**MORGAN AND MORECAMBE OFFSHORE WINDFARMS TRANSMISSION ASSETS:**

**DEADLINE 5 – COMMENTS ON SUBMISSIONS RECEIVED BY DEADLINE 4.**

### **Comments regarding: FLOOD RISK ASSESSMENT REV.04 [REP4-021] [REP4-023], [REP4-025]**

Figure 1.16a: Defended 1% AEP fluvial event plus 20% climate change uplift

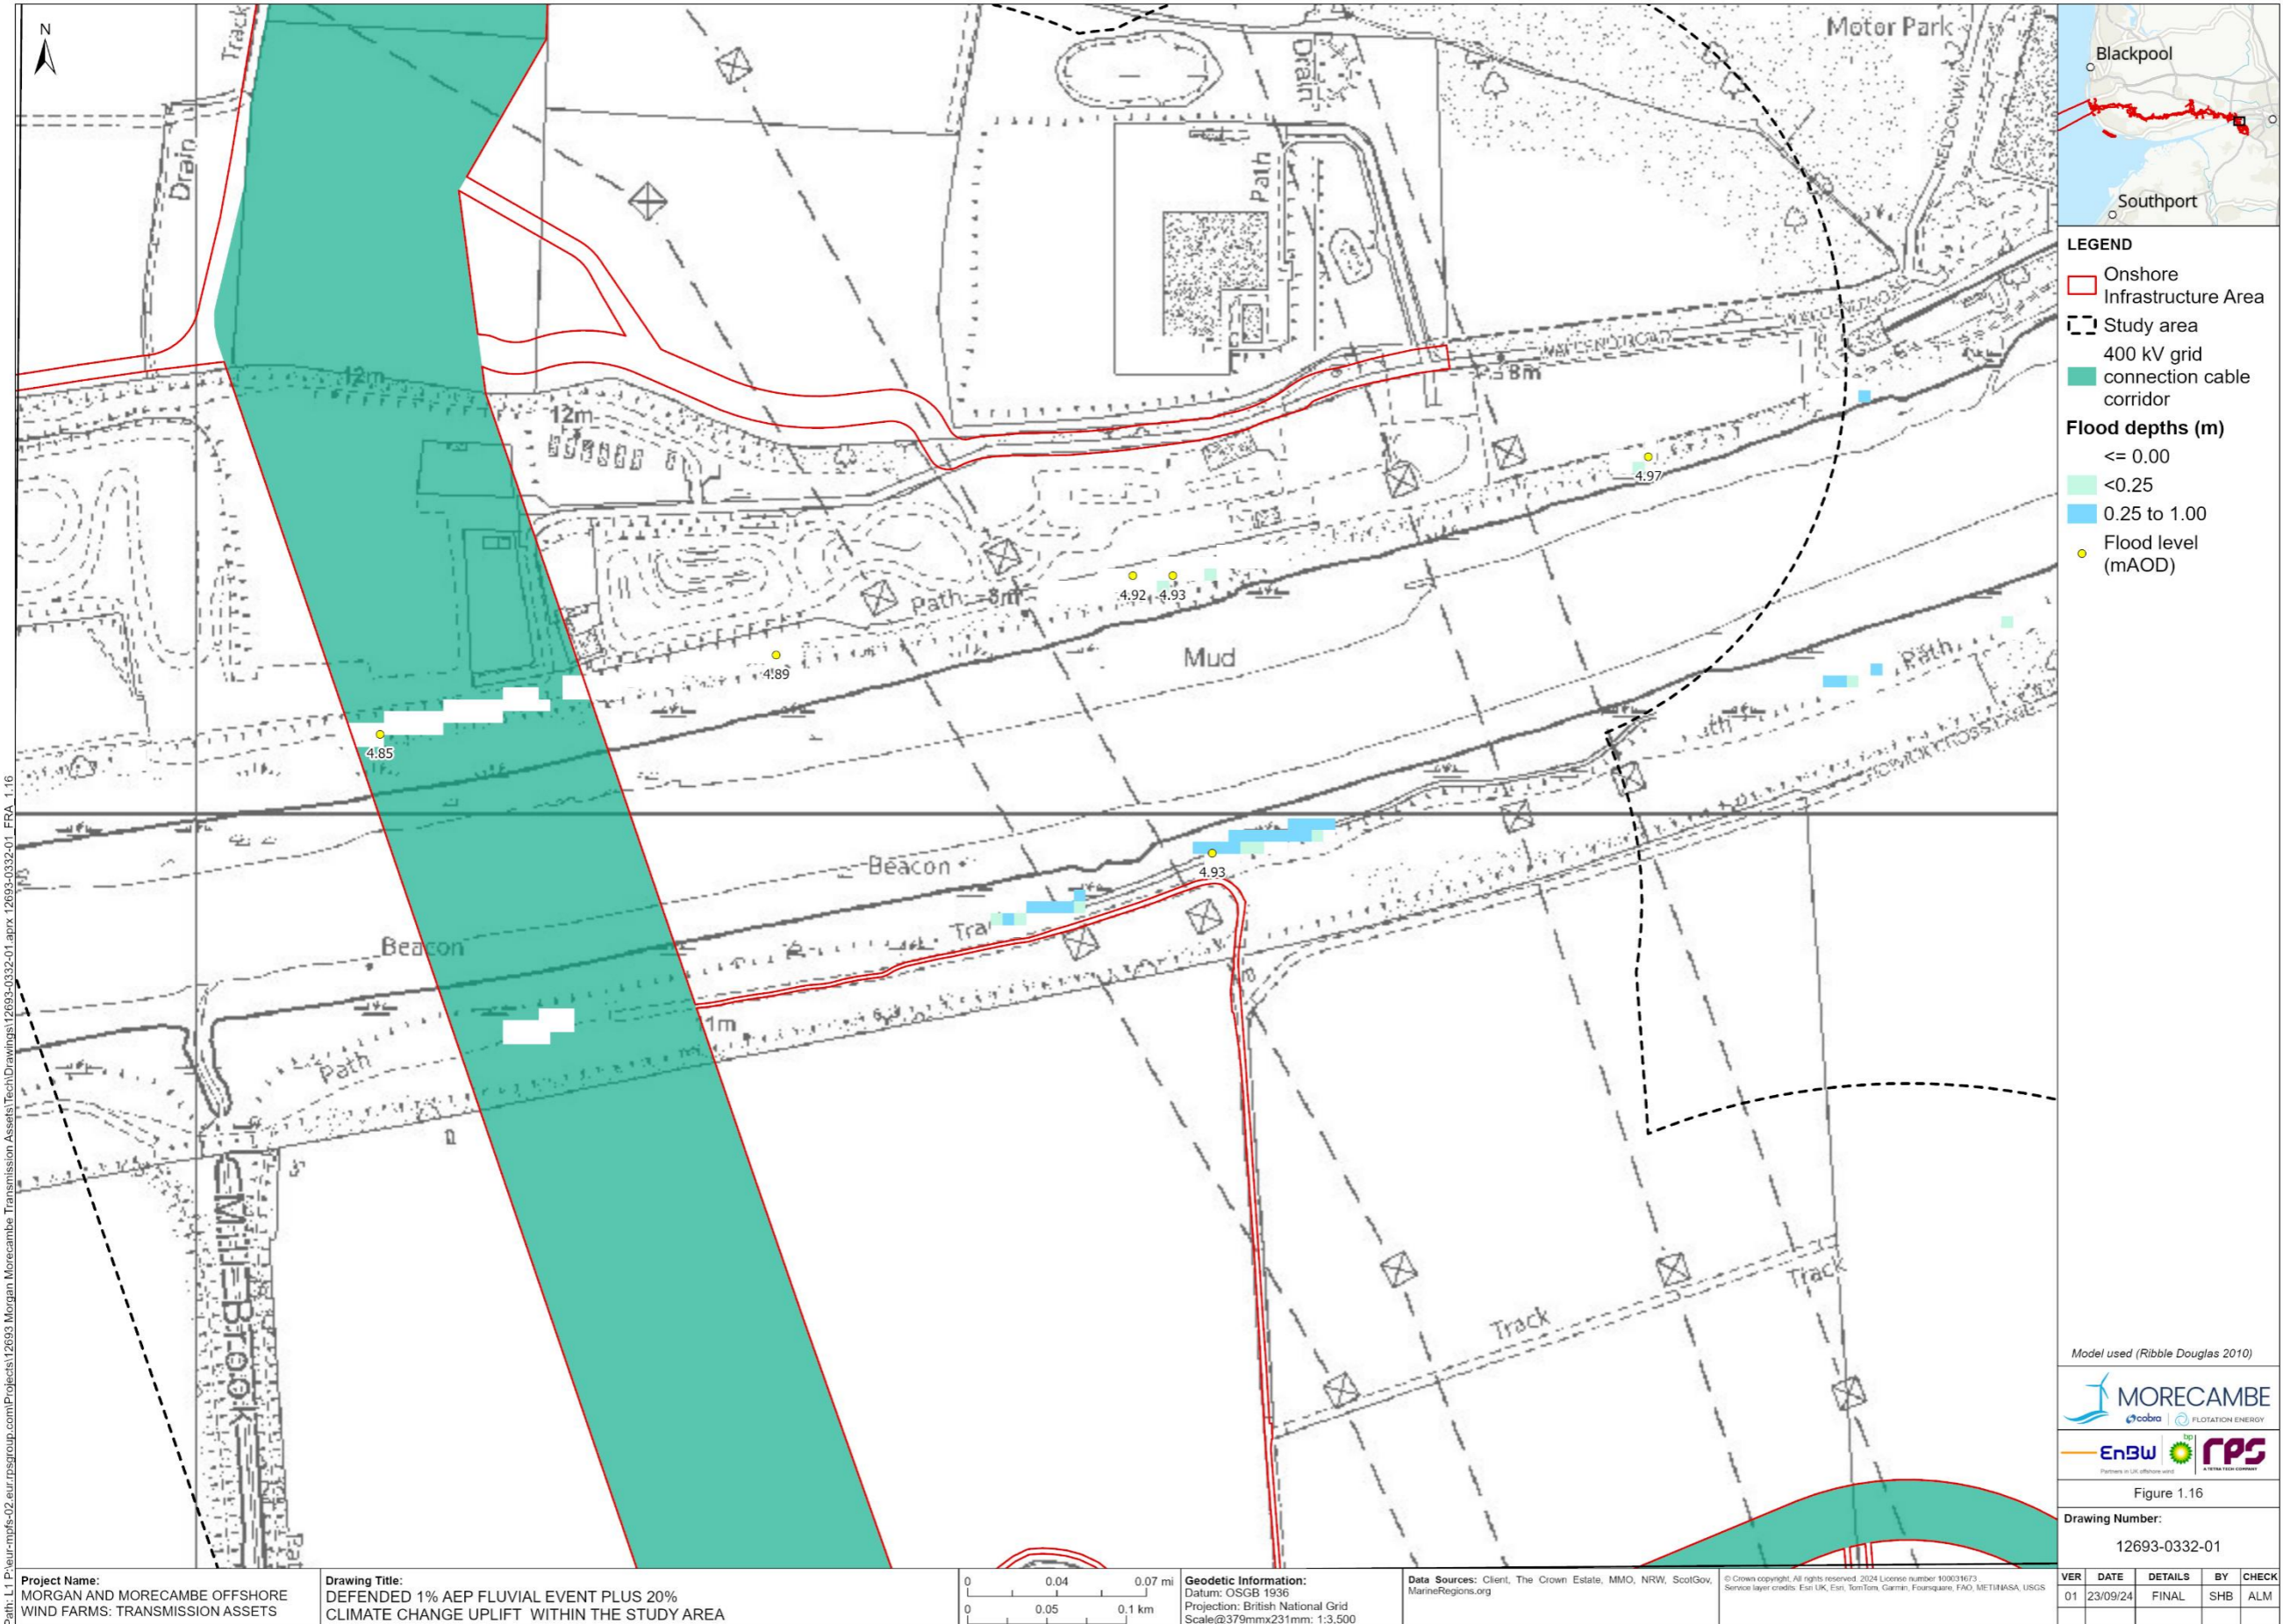
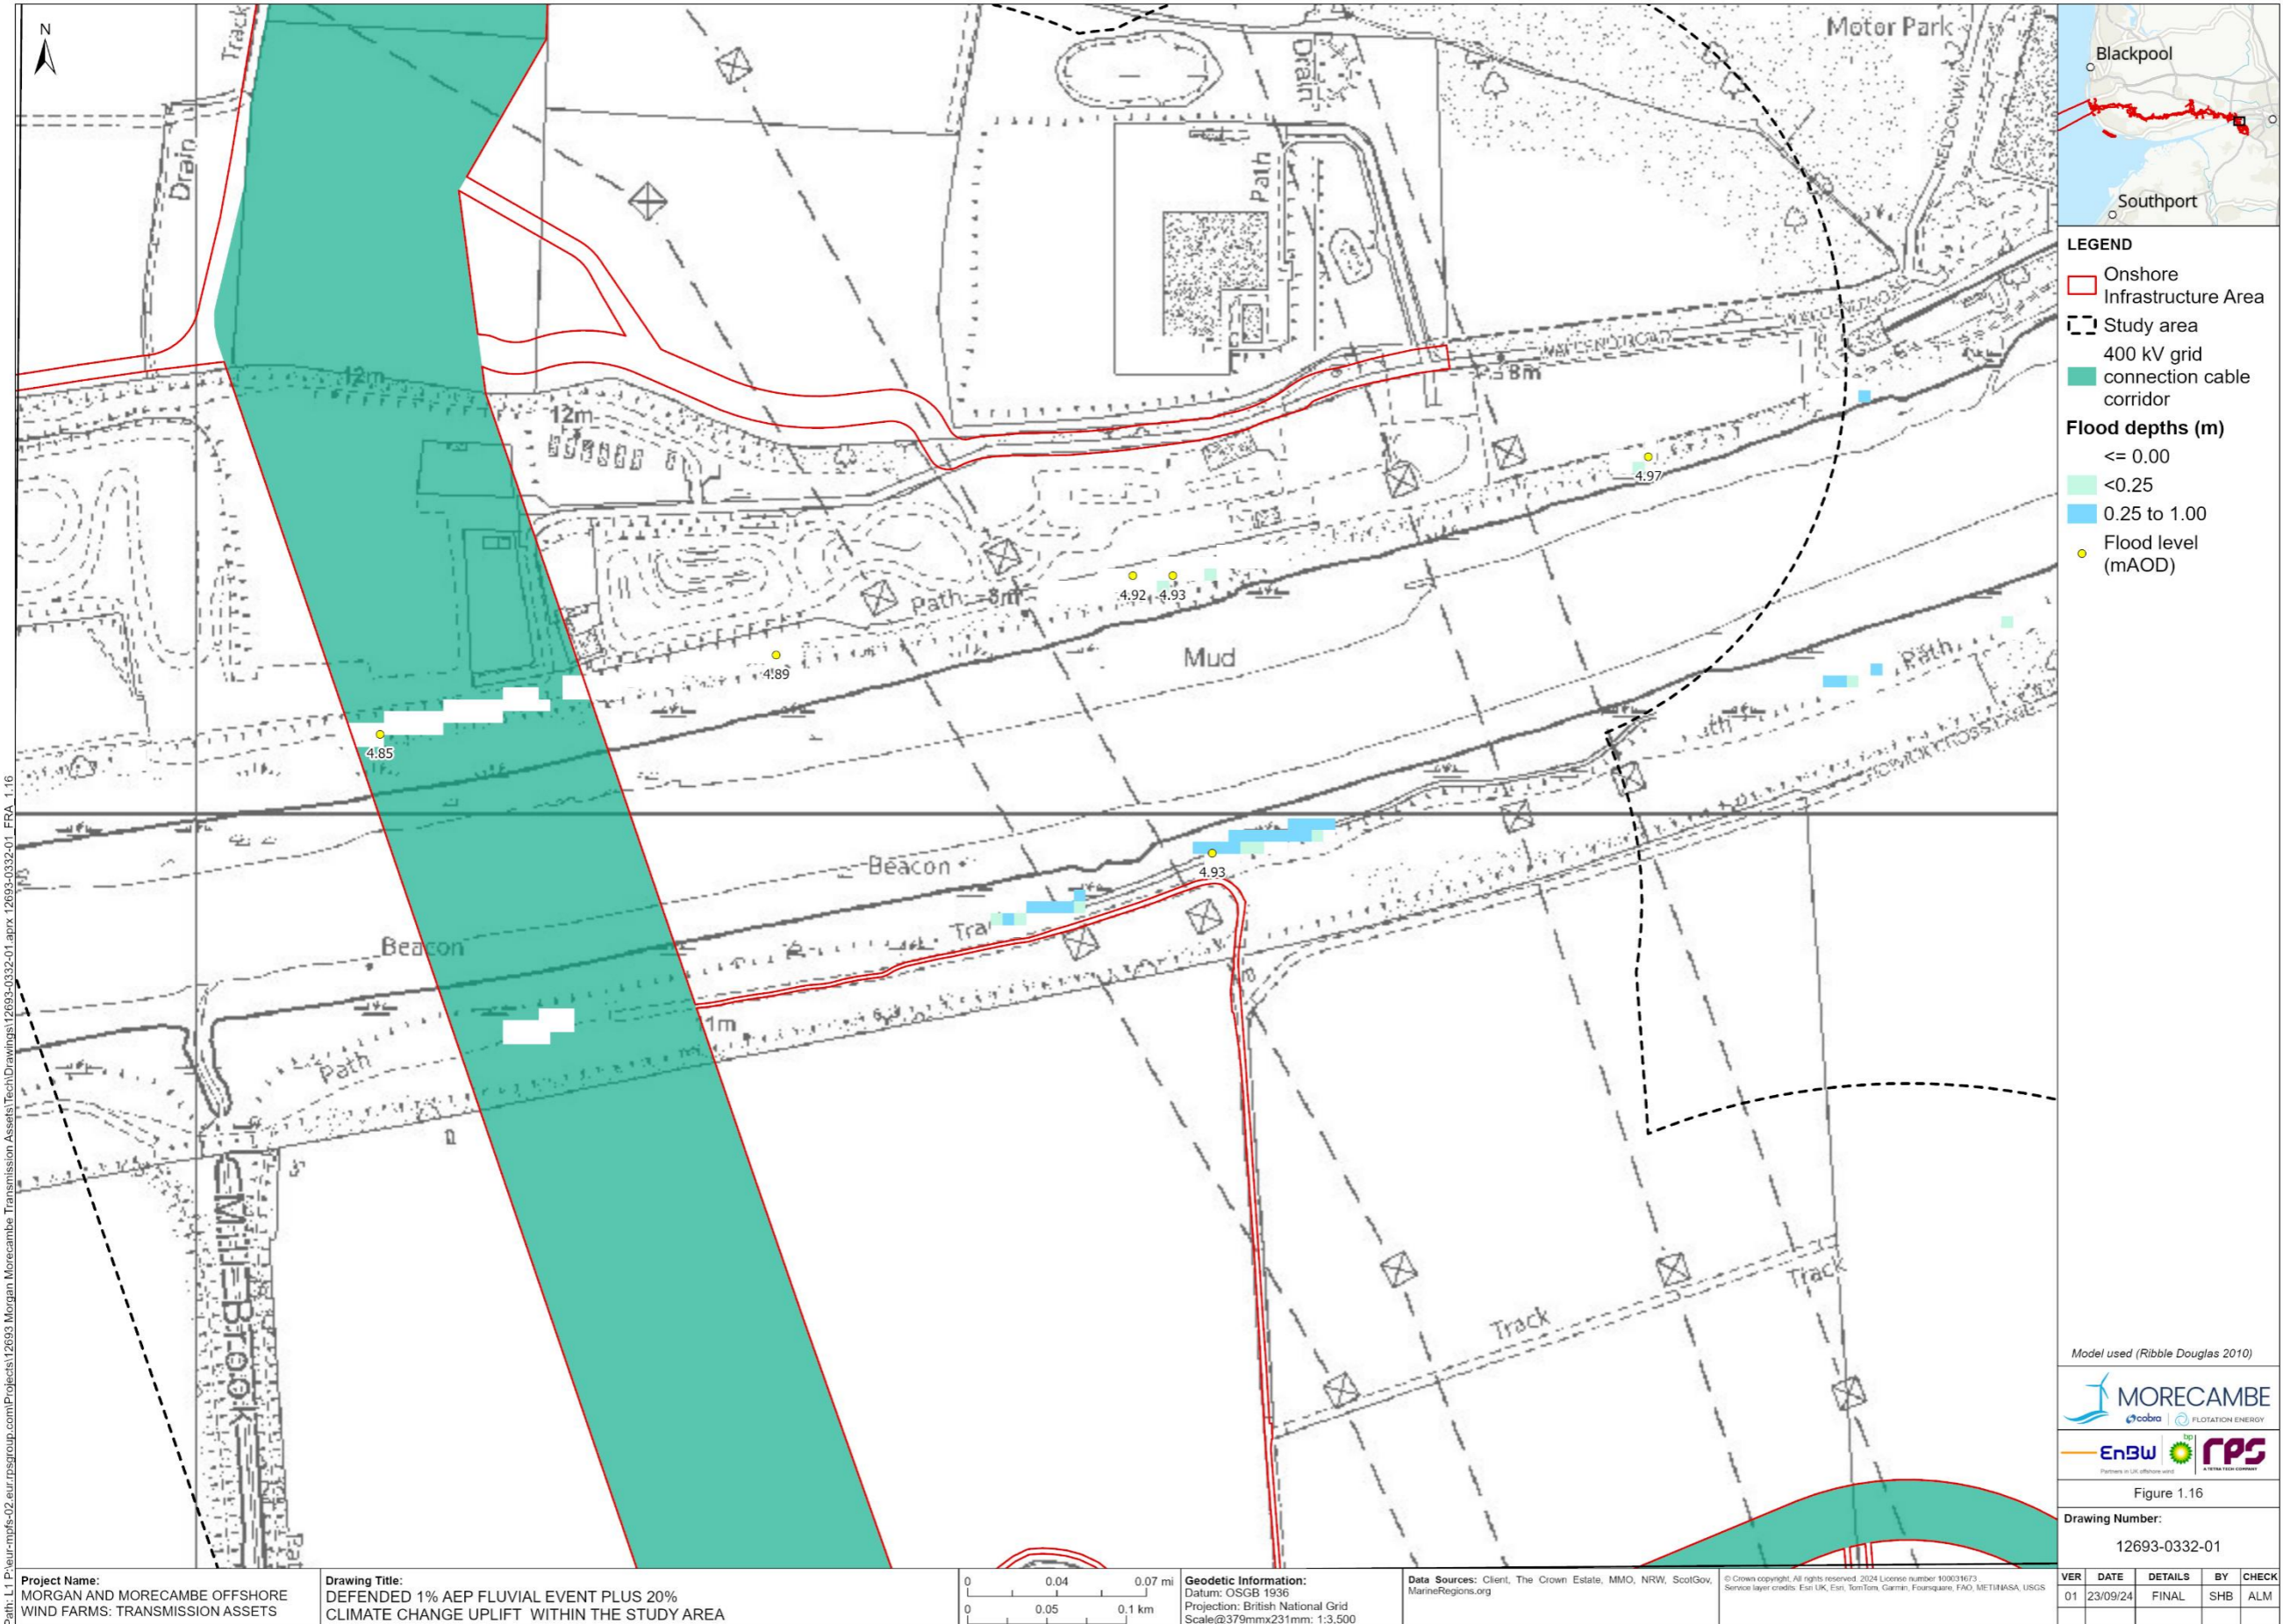
<p>Like previous comments.</p> <p>Changing in titles and figure numbers appears to have resulted in a discrepancy between the new figure label in the report and the figure reference in the original title box of the drawing.</p> <p>e.g. Figure 1.23: Undefined 1% AEP fluvial event plus 20% climate change uplift on Page 199 is figure 1.17 in the drawing title box.</p>	This makes referencing somewhat problematic and confusing.	Clerical error requiring correction
--	---	--	-------------------------------------
